Consultation Response from: KC Environmental Health (Pollution & Noise Control)		
2025/91138 - The Chartist, 74 Commercial Road, Skelmanthorpe, HD8 9DS		
Discharge of details reserved by condition 1, 2, 3, 5, 7, 8, 9, 12, 13, 14, 15, 17, and 18 on previous permission 2023/92551 for outline application for erection of residential development (within a Conservation Area)		
Responding Date: 29 th May 2025	Responding Officer: SR- 7,8&9 MN- 12	Responding Ref: WK202513833
<u>Comments</u> Environmental Health have been consulted in relation to conditions 7,8,9 and 12 ONLY. <u>Condition 7 Preliminary Risk Assessment (Phase I Desk Study Report)</u> In support of the discharge of the condition, a Phase I Desktop Study and Preliminary Risk Assessment Report by GeoEnviro Solutions Ltd, ref: 4017-23 PI, dated August 2023 has been resubmitted. We have already commented on this report in our response to the outline application dated the 18th of October 2023. The applicant has supplied an intrusive investigation by Haigh Huddleston and Associates, ref: - E24/8229/R001A to fully support the discharge with an appraisal of the Phase 1 report, revised preliminary conceptual site model and an updated c

Appendix 2 – Noise Measurement Positions

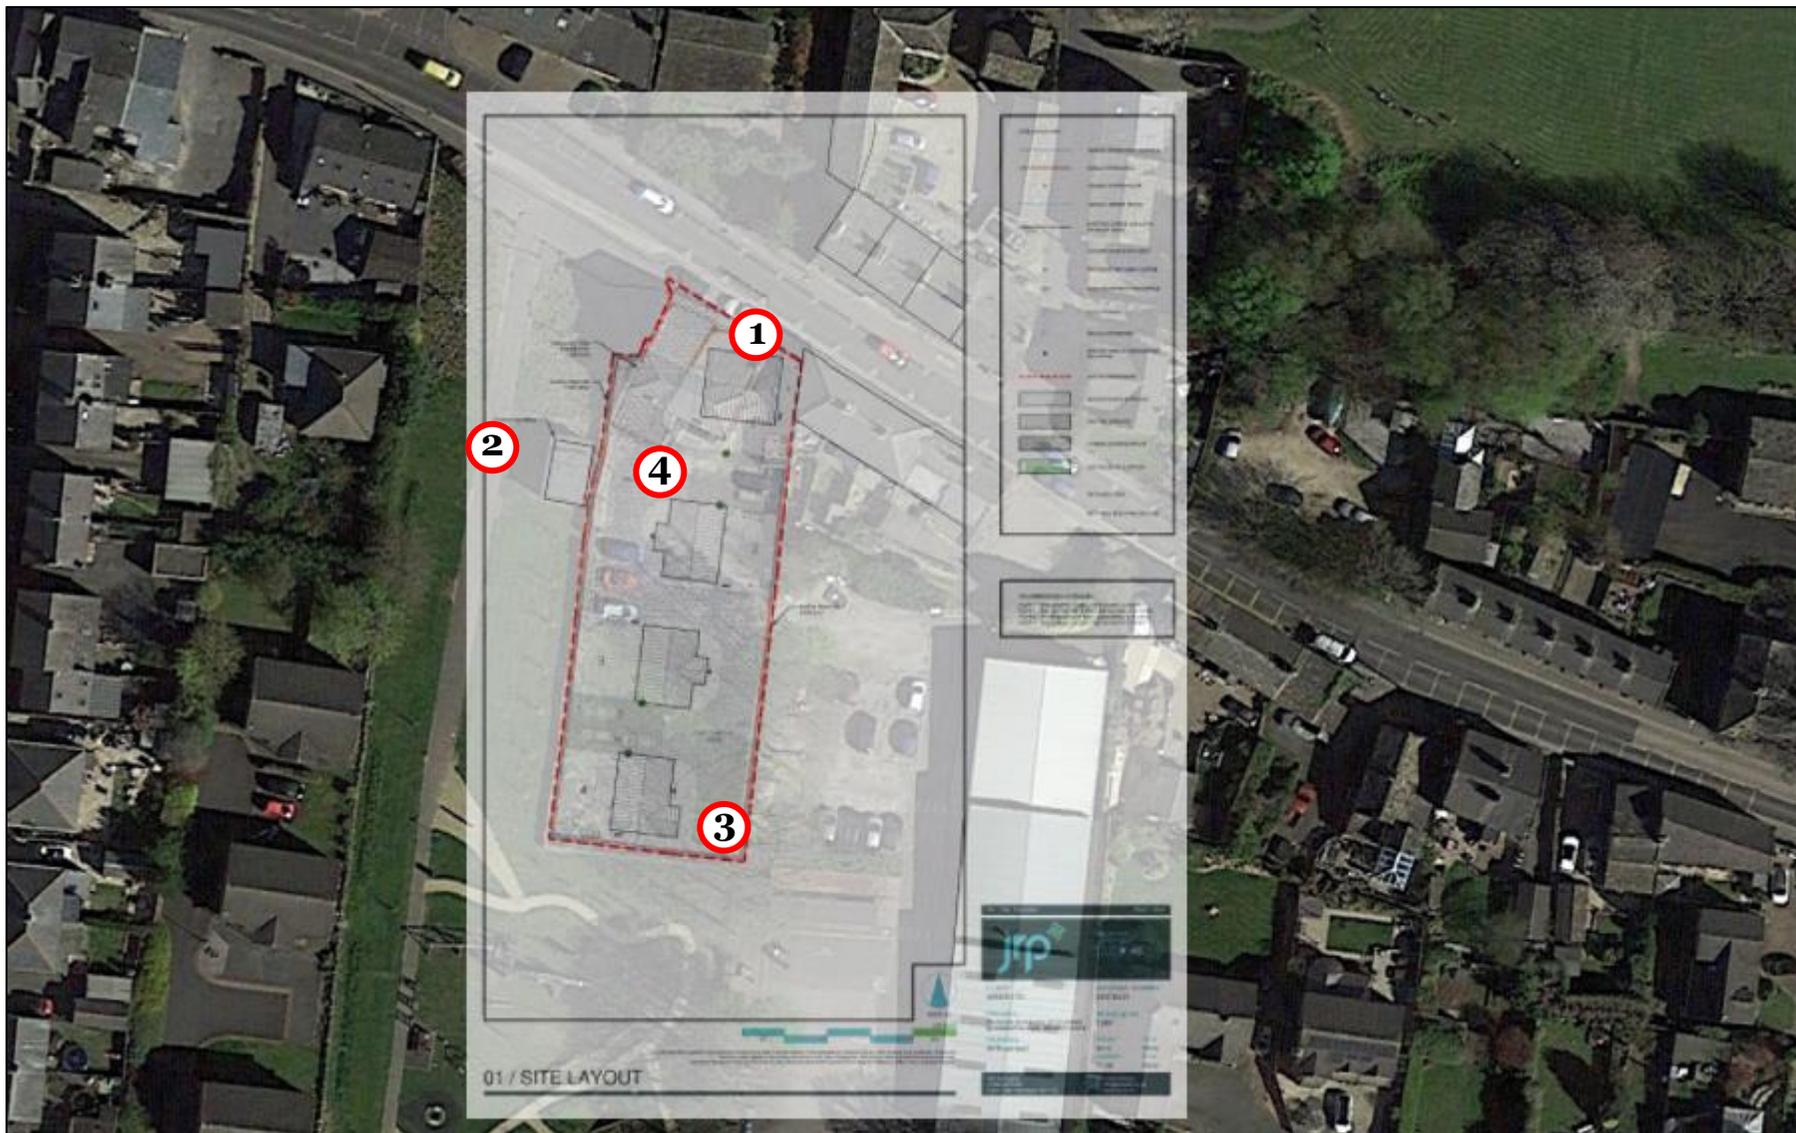
Noise monitoring was conducted on Thursday the 19th of December 2024 and the early hours of Friday the 20th of December 2024 with additional monitoring undertaken on Thursday the 9th of January 2024 (should read 2025). The adopted noise monitoring positions are shown in Appendix 2 and a summary of the findings is given in table 3.1. The ambient noise climate at the site was dominated by road traffic on Commercial Road, with no other significant noise

Whilst the mitigation measures are predicted to ensure the development site meets with the relevant standard based upon the findings of the monitoring exercise, we have concerns that it did not consider the use of the public open space with likely elevated noise levels, in the summer months. We note the monitoring was conducted in December/January and ask that this exercise be repeated either in person or using library data and the mitigation measures amended if deemed appropriate. We also take this opportunity to ask for comment upon the electrical substation and whether and consideration has been given to any noise emissions, in particular low frequency sound.

We ask for further information to be submitted to address our concerns and as such, recommend the condition is not discharged at this time.
